Application Reference: 2025/0709

Site Address: 35 Moorland Crescent, Staincross, S75 6NT

Introduction:

This application seeks full planning permission for a single storey side extension and removal of door on opposite side of dwelling.

PROPOSED GROUND FLOOR PLAN
SCALE 1:100 AT A3

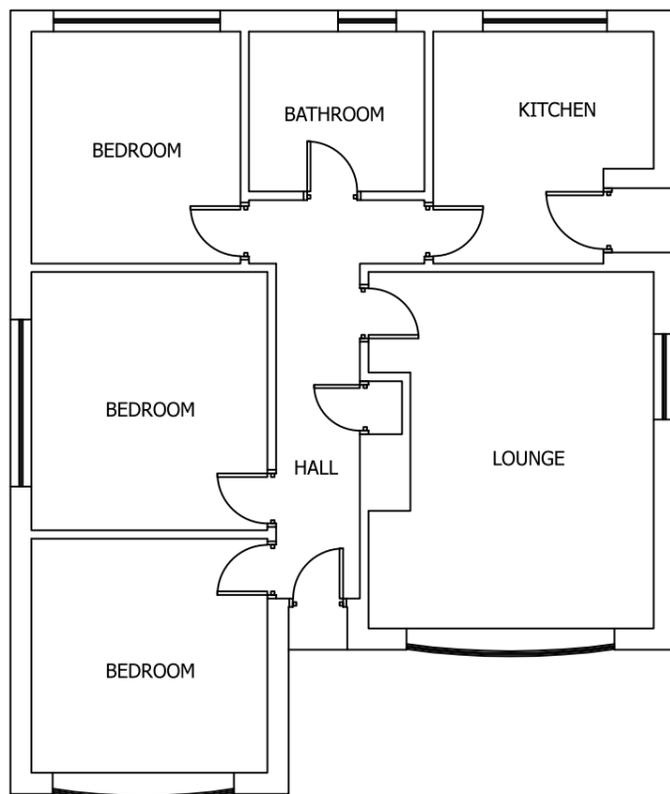
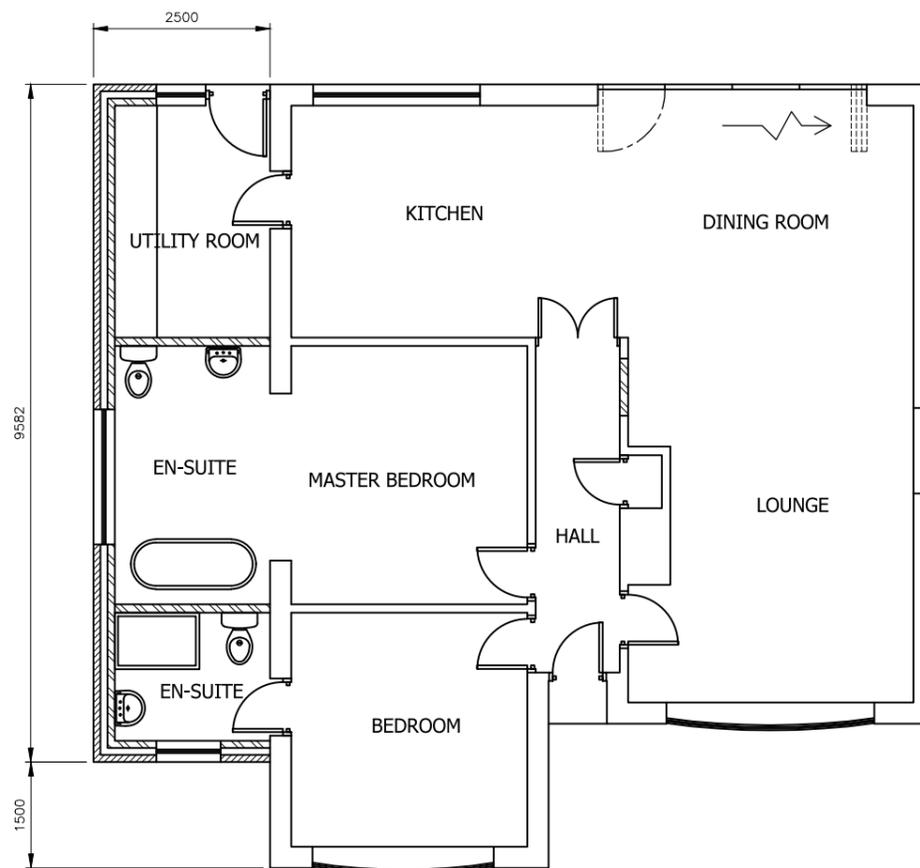
The proposal will create two en-suites and a utility room at the rear and will allow for the reconfiguration of the internal layout to provide an open plan lounge/kitchen/dining room. The kitchen door on the northern elevation will be removed.

Drawing Title
PROPOSED ELEVATIONS

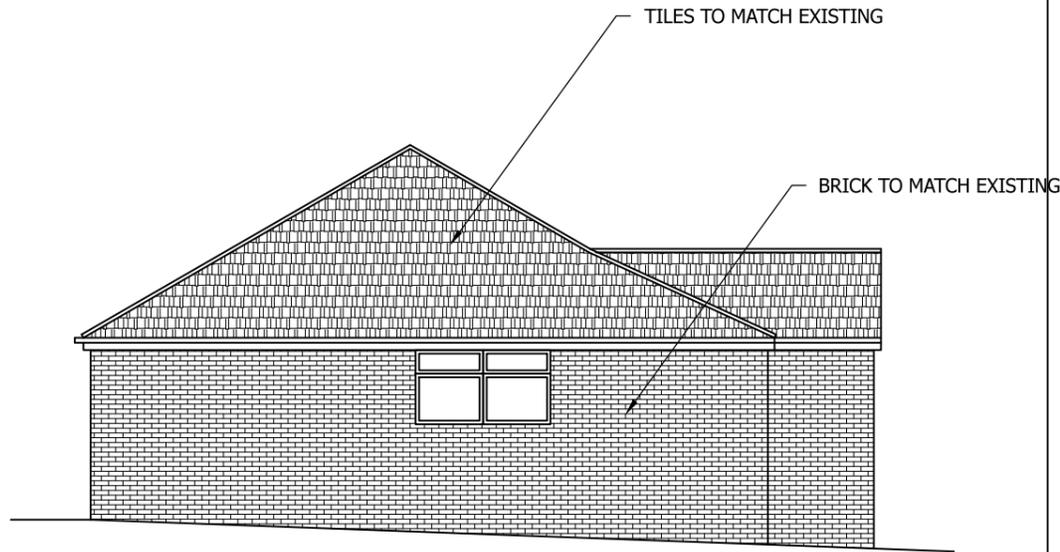
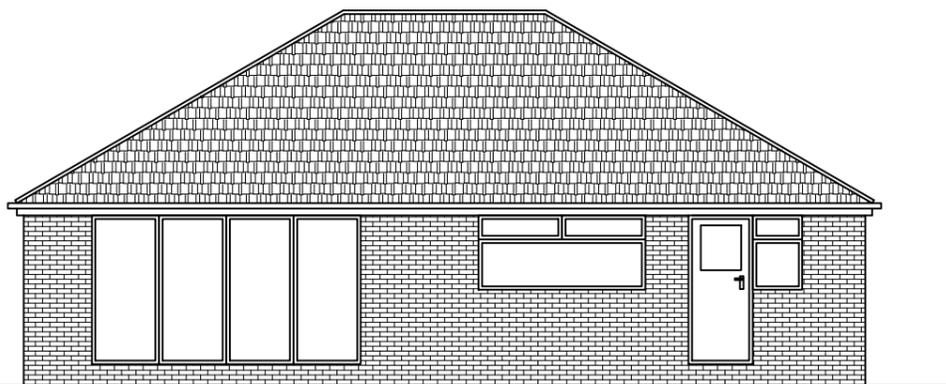
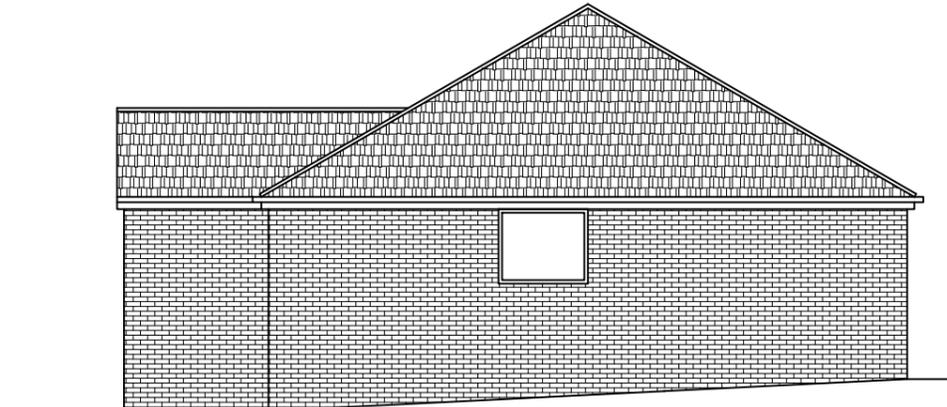
The proposed extension is set back from the front projection by 1.5m creating a visual break. The roof style and pitch will tie in with the existing and when viewed along with the matching materials is not expected to be an incongruous feature within the street scene. As the proposal is located on a corner plot the sideways projection has been measured and is found to comply with the above criteria when measured from the widest part towards the rear of the property.

The proposed side elevation will face Moorcroft Rise. The window proposed along the side elevation serves a bathroom therefore potential overlooking from this elevation is not expected. The proposal will provide a utility room to the rear of the property therefore potential overlooking from the proposed window and door serving this room is also not expected.
